OUT19/8880

**Marulan South Limestone Mine Continued Operations Project (SSD-7009)
EIS Exhibition**

ATTACHMENT A

Marulan South Limestone Mine Continued Operations Project (SSD-7009) EIS Exhibition

Figure 2: Marulan Creek Dam Layout

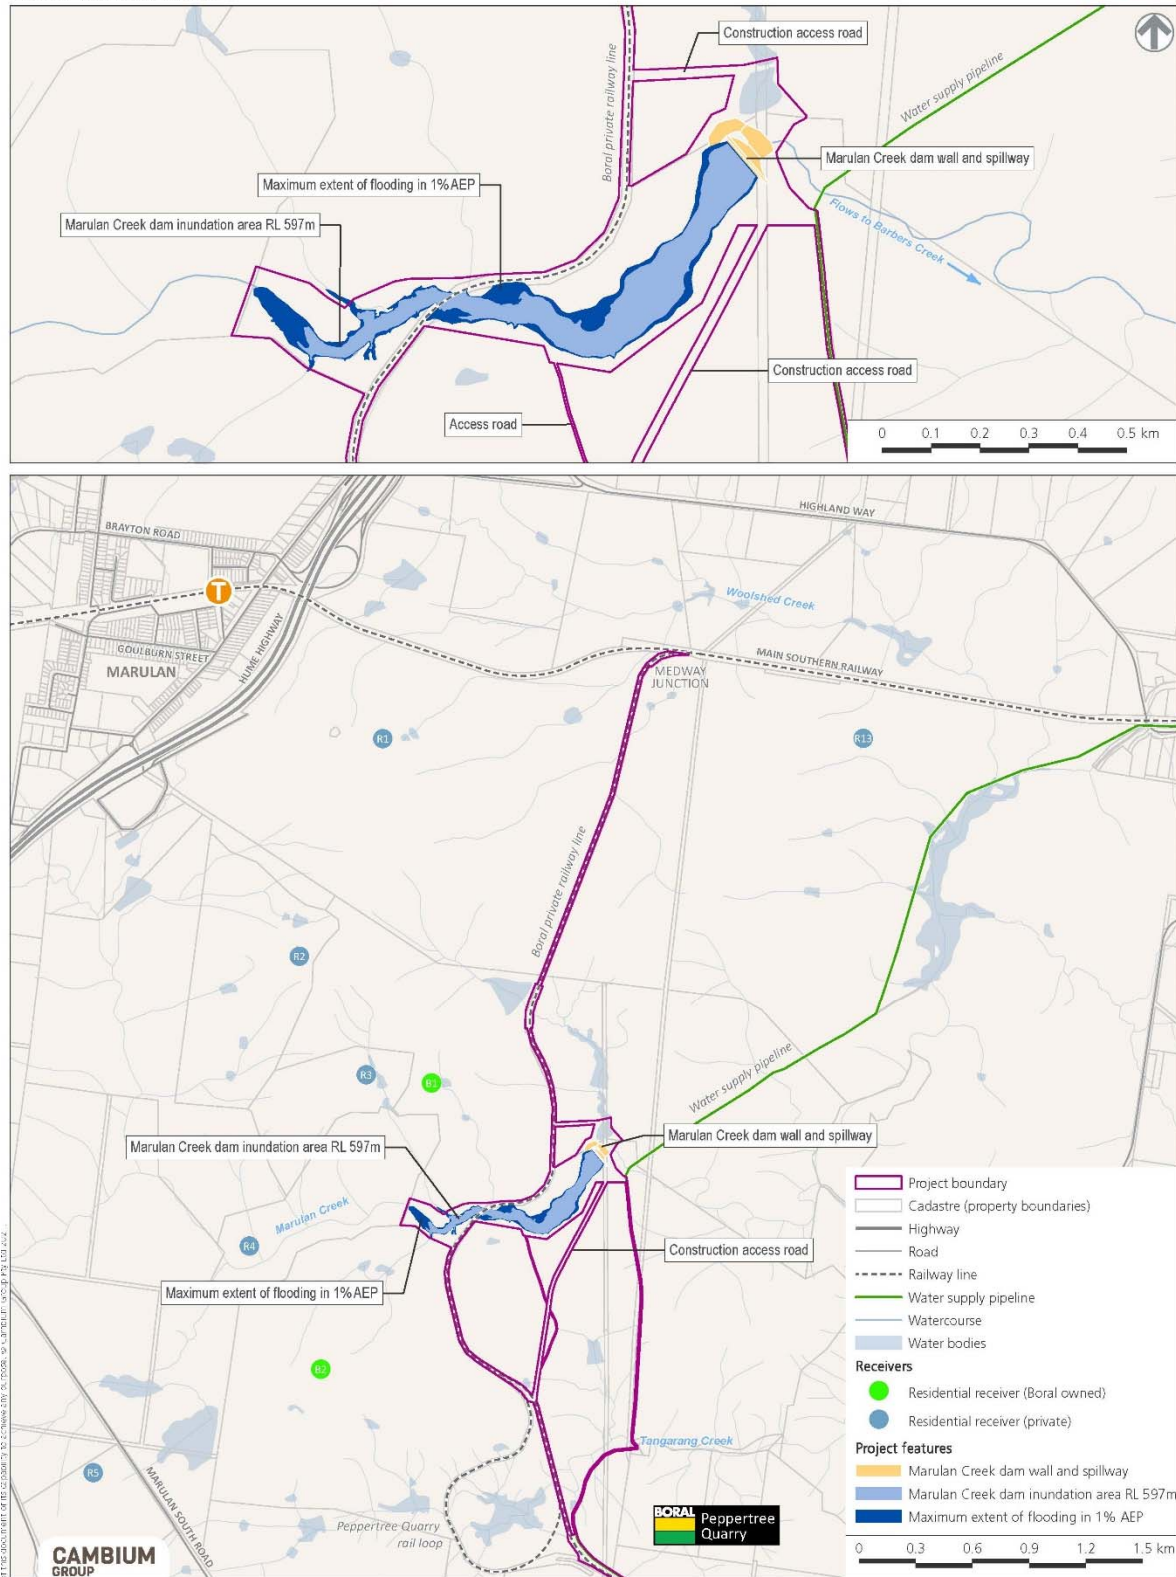
- An alternative to the proposed dam located on Marulan Creek, for securing a suitable water supply because the current location does not comply with: (a) the rules of the Water Sharing Plan for the Greater Metropolitan Unregulated River Water Sources 2011; and (b) the Guidelines for Controlled Activities on Waterfront Land Riparian Corridors (NRAR, 2018). Please see **Attachment A** for detailed comments.
- An alternative method of water take, other than the proposed harvesting of sediment-laden water.

DPIE - Water does not support the request for additional on-line dam located on Marulan Creek, and recommends the proponent locate an alternative water supply because:

Marulan Creek is within the Barbers Creek Management Zone, where new in-river dams are prohibited under Clause 62(5) of the *Water Sharing plan for the Greater Metropolitan Unregulated River Water Sources 2011*. This is part of a general prohibition on new in-river dam construction in the Shoalhaven and Sydney Basin water sources, apart from a limited range of town water supply or major water utility access licence structures.

As per the guidelines, online detention basins are not permissible on 3rd order streams and above (see Table 2 'Riparian Corridor Matrix', in the guidelines), and Marulan Creek is classified a 4th order stream.

The proposed dam will likely reduce total flows downstream into the Barbers Creek gorge and flow variability and ecological resilience within the channel and fringing zone. Additionally, likely cumulative impacts on flow dependent species have not been assessed. The EIS does not present analysis of reducing flow variability on sediment transport or interruption of geomorphic processes in Barbers Creek.
